Application number: 2019/91141	
What is the application for?:	Outline application for erection of one detached dwelling
Address of the site or building:	adj, 320, New Hey Road, Oakes, Huddersfield, HD3 4GQ
Postcode:

Here is my objection for this planning application: Number: 2019/60/91141/

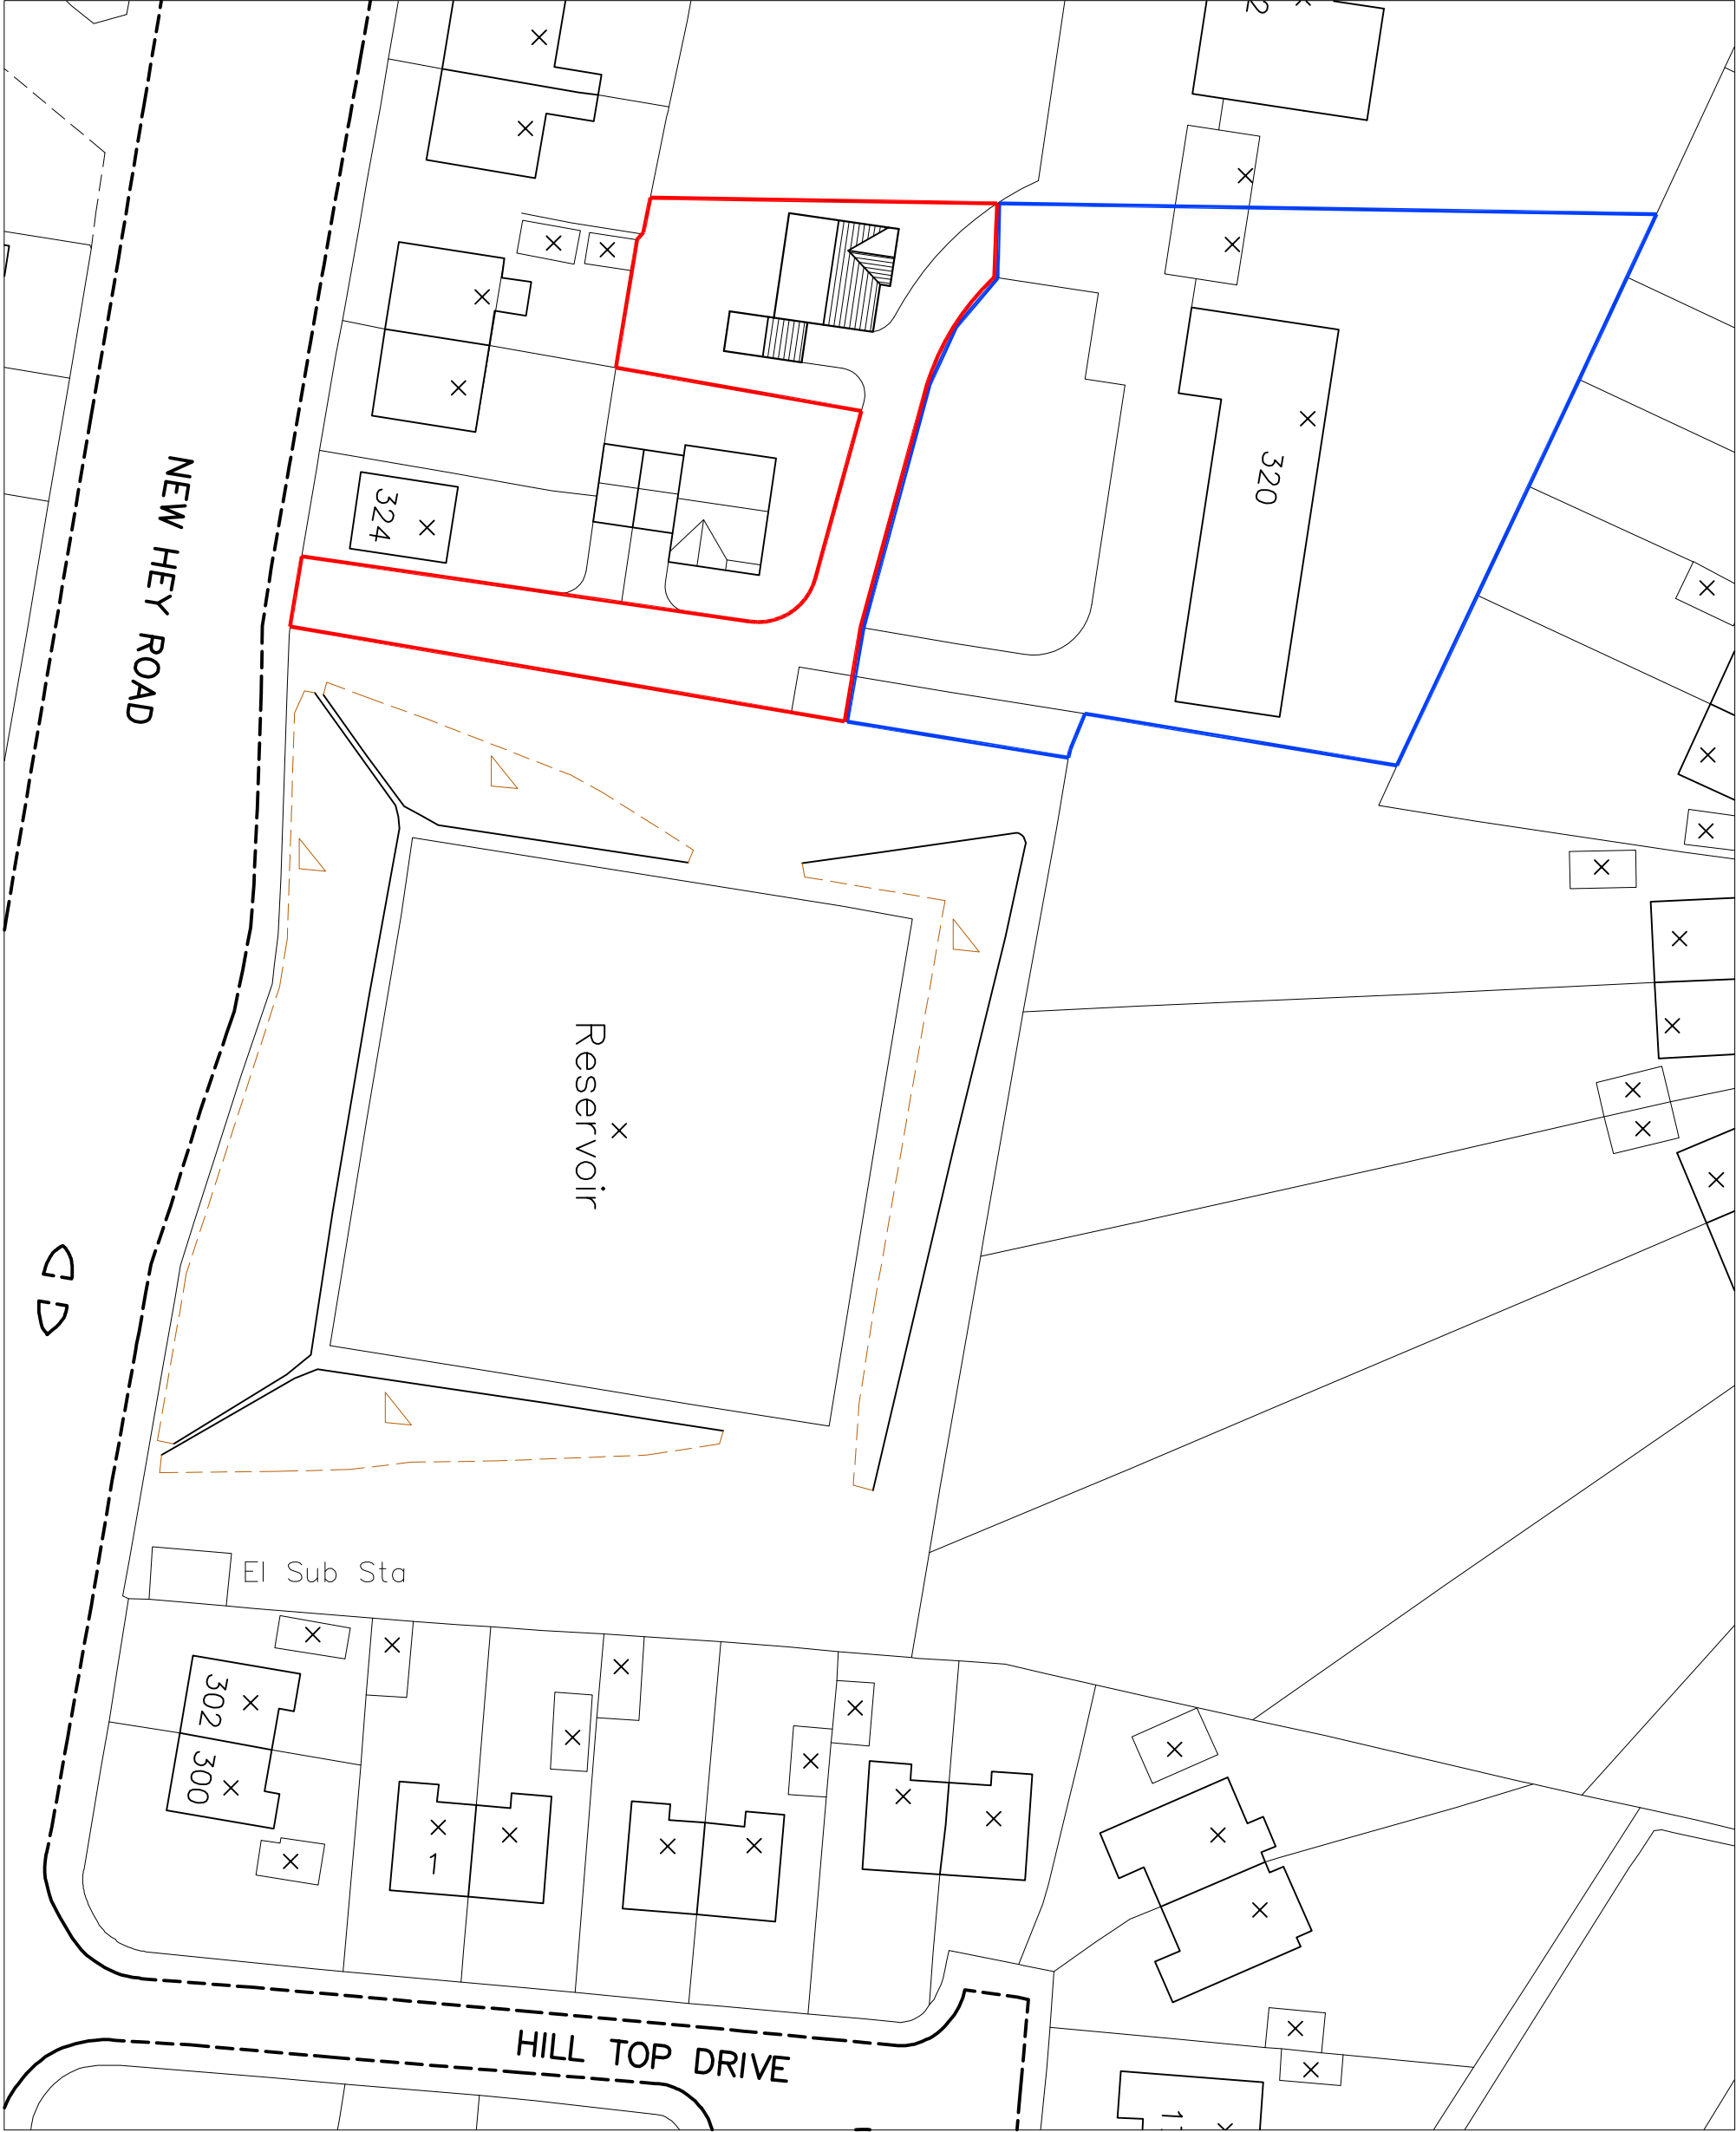
Design, layout on these two pdf documents "2019-91141_+Location+Plan_743433.PDF" and "2019-91141_+Proposed+Site++Block+Layout_743435.PDF" is an incorrect representation to how the area is.

The Design, layout does not take into the account the land registry of title number YY13772. i.e. House Number 318, built in 2012.

**There is no land available for the "Garage serving No. 324 as approval - 2008/91696."

**The two parking bay belonging to 318 is not represented on the design, layout.

**The red lines on "2019-91141_+Location+Plan_743433.PDF" are incorrect.
